From: Simon Davis
Sent: 05 January 2022 14:58
To: Kerry Simmons [REDACTED]
Cc: Natalie McKellar [REDACTED]
Subject: RE: Planning Consultation on: Y/158/21/PL

Engineers Comments Regarding Surface Water Drainage

The drainage design for the previously approved scheme was approved under Y/17/21/DOC. We have completed a review to understand the changes between the previously approved drainage design and the current proposals.

Drainage Details

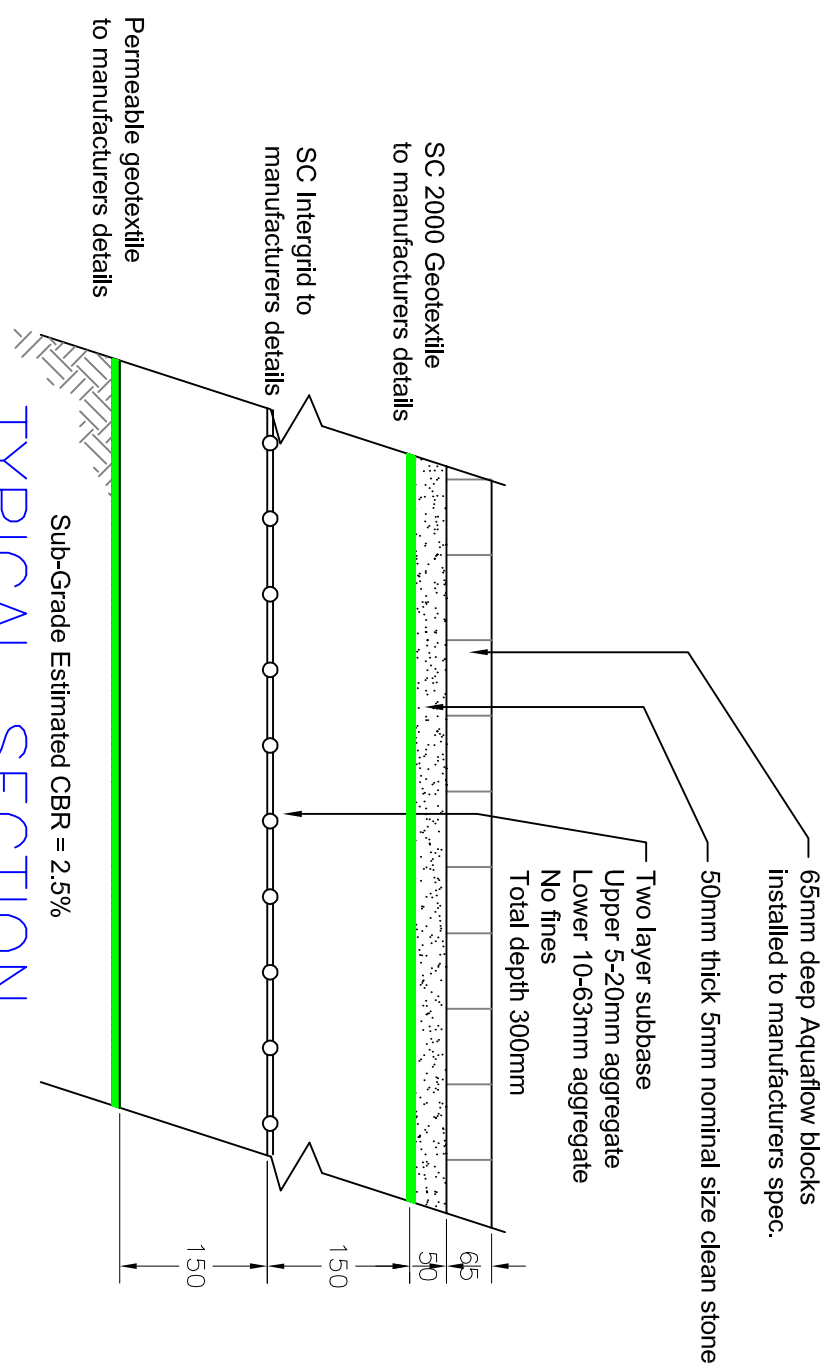
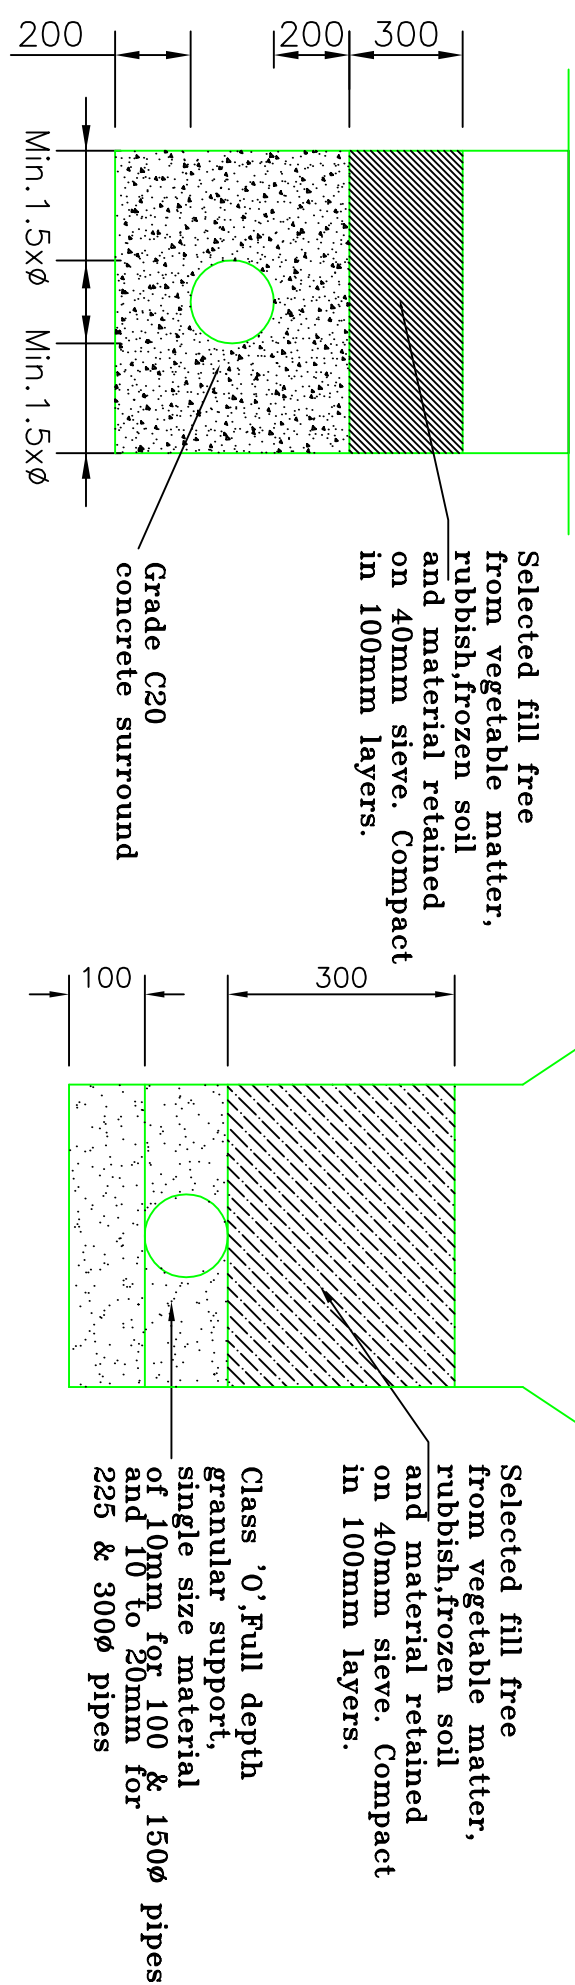
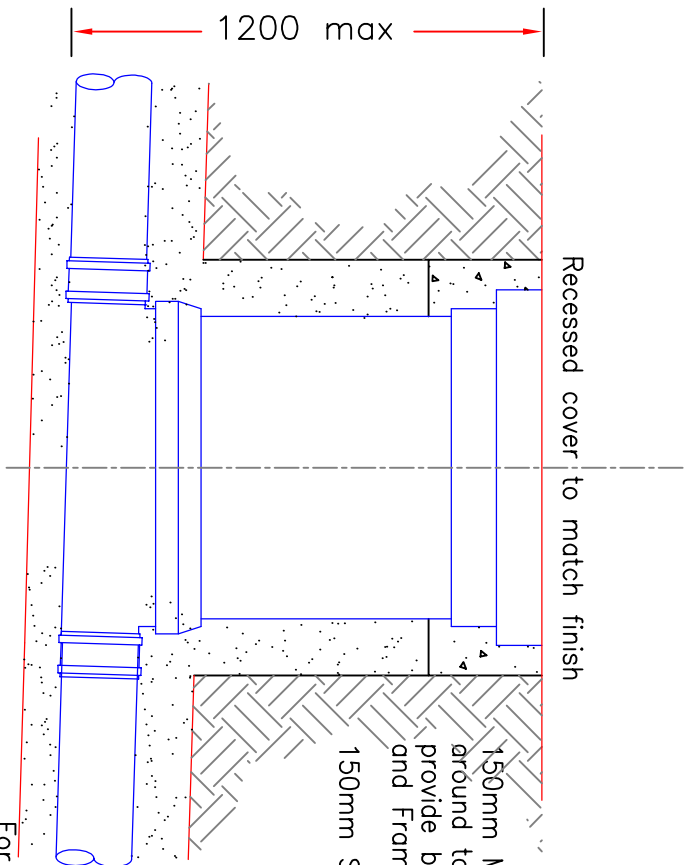
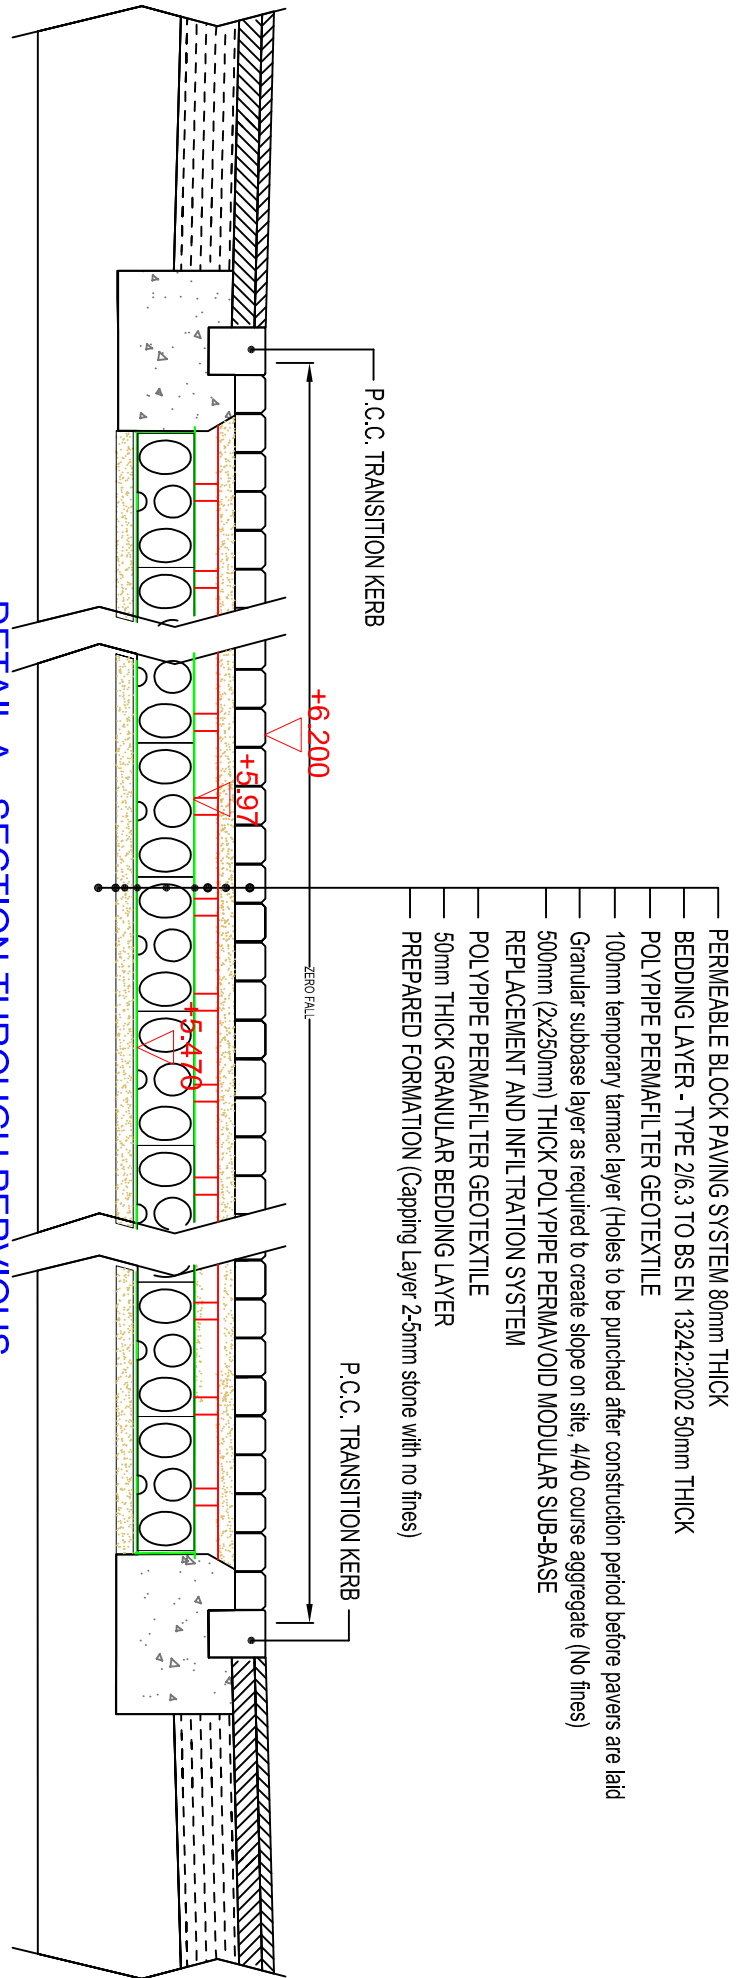
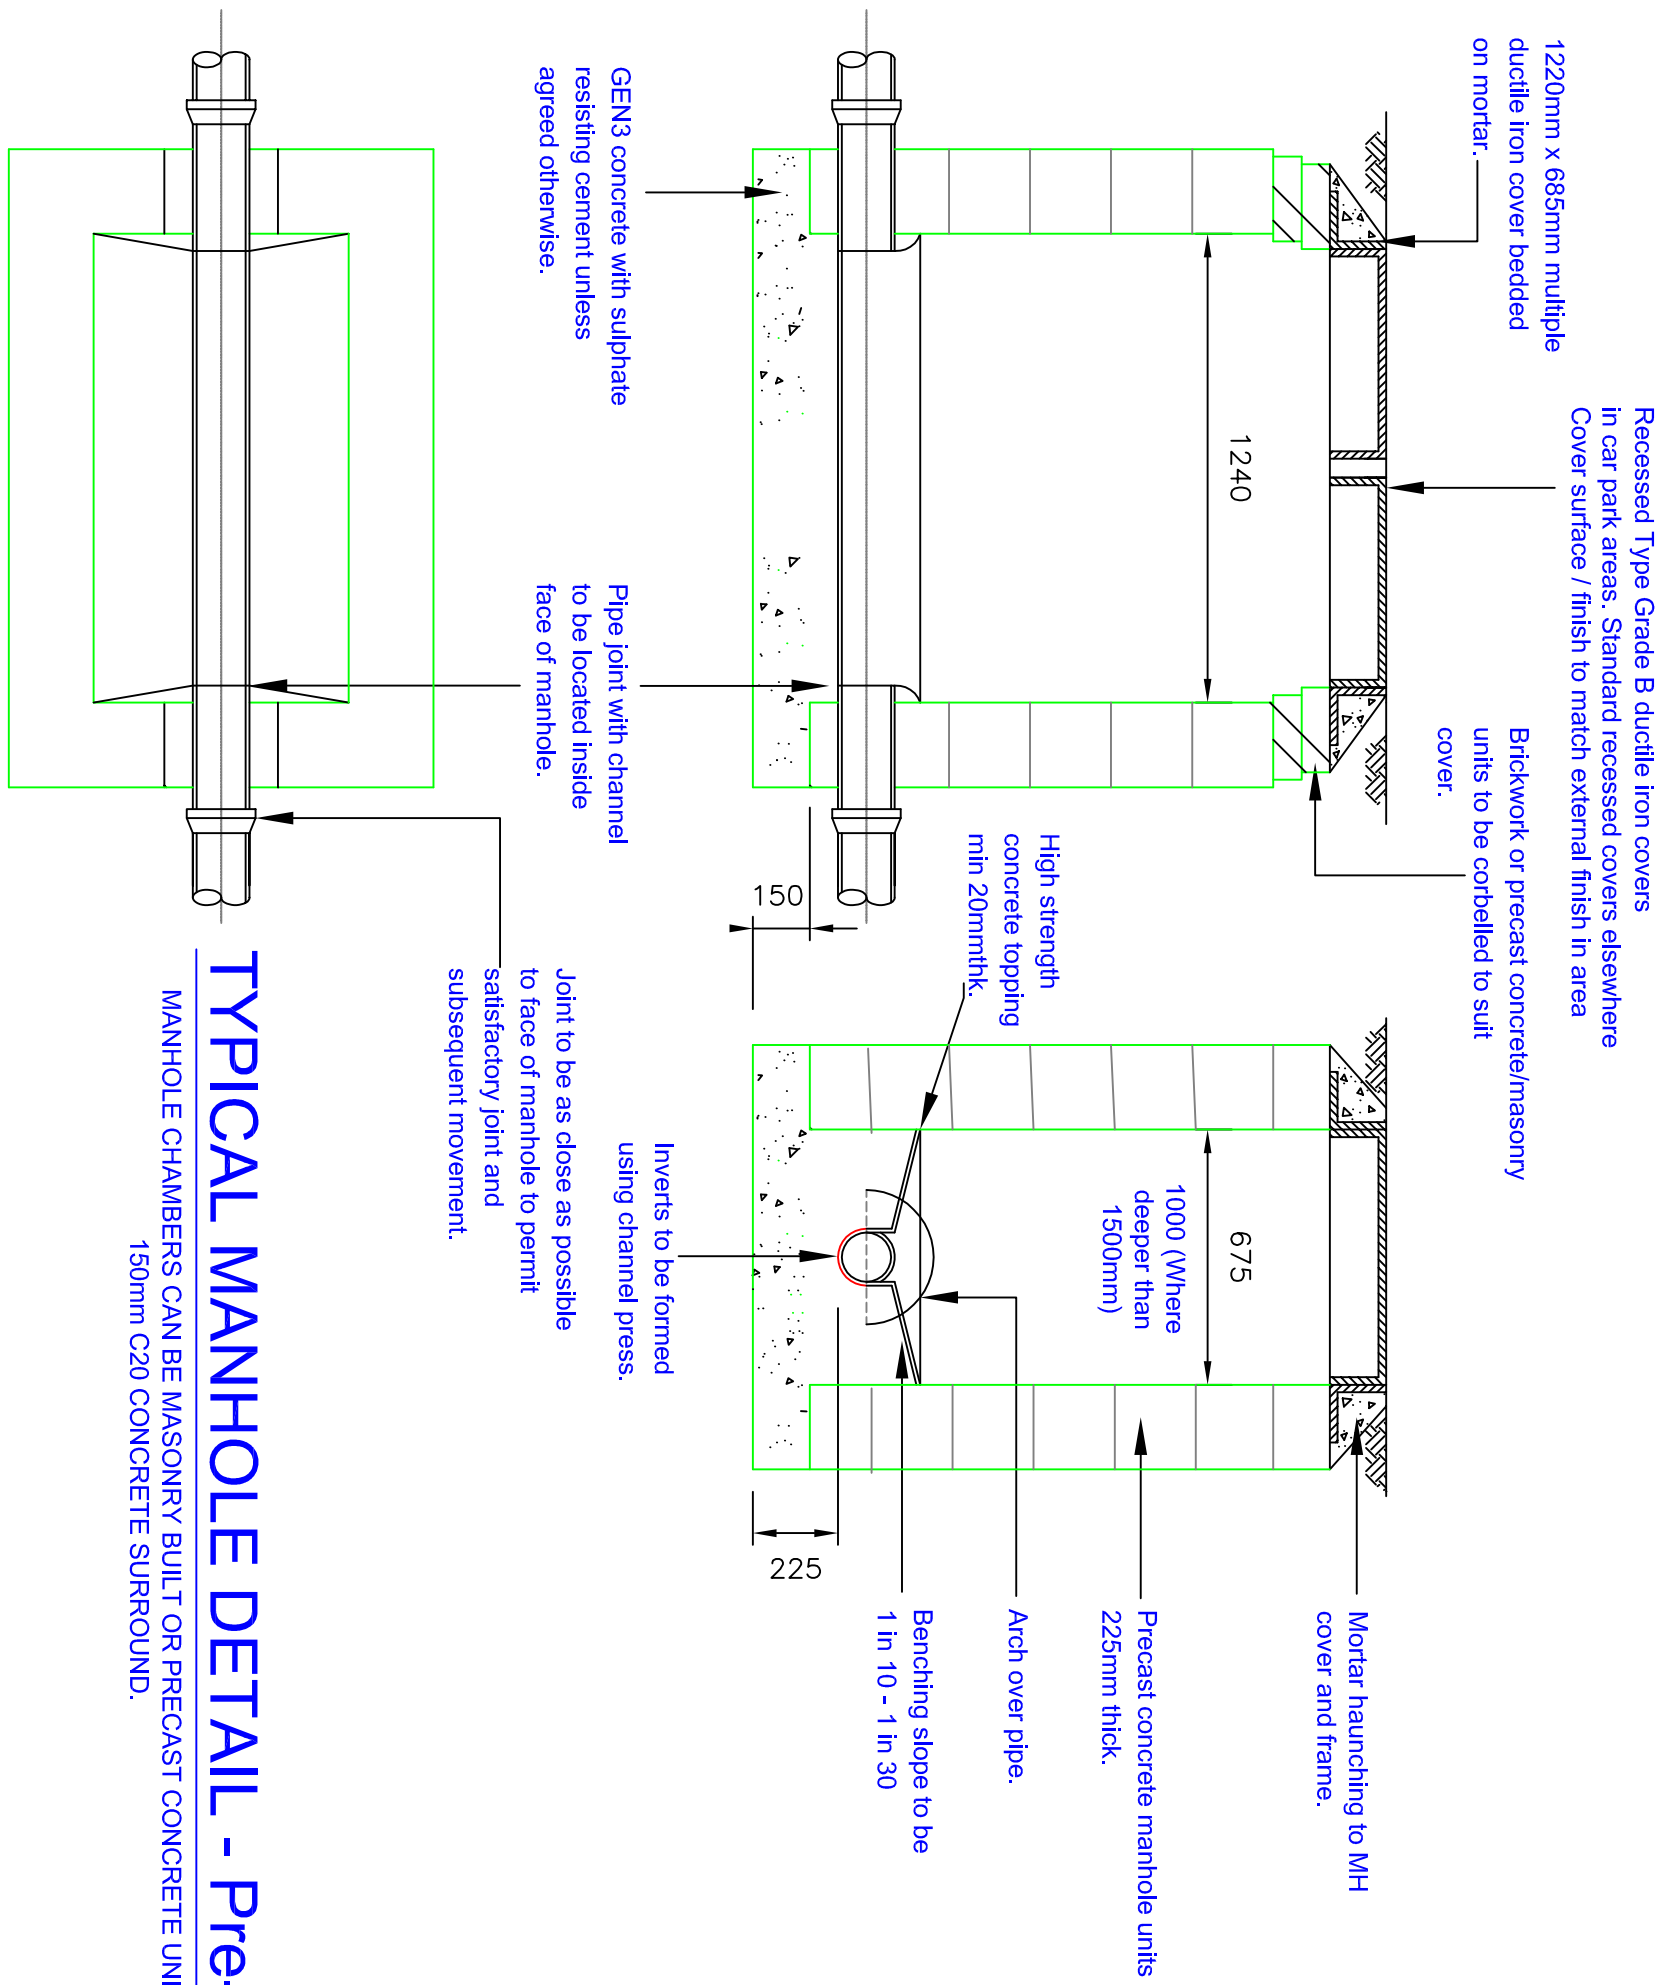
1. The majority of the permeable paving area is proposed to have an increased construction depth of 100mm, this is applied by reducing the formation level by 100mm.
2. Inlets to permeable paving for plots 1, 2 and 3 appear to be very closed to proposed buildings. Please ensure that inlets are a minimum of 5m away from buildings.
3. The levels around plots 9 and 10 appear to be higher (circa 350mm) than those previously proposed, we would like to highlight this to the case officer, and suggest a comparison is completed of FFLs.
4. We request that the make up of any capping material below the permeable paving is clearly defined. This must be a permeable material.
5. The management manual should contain a copy of the drainage layout and construction details within an appendix.
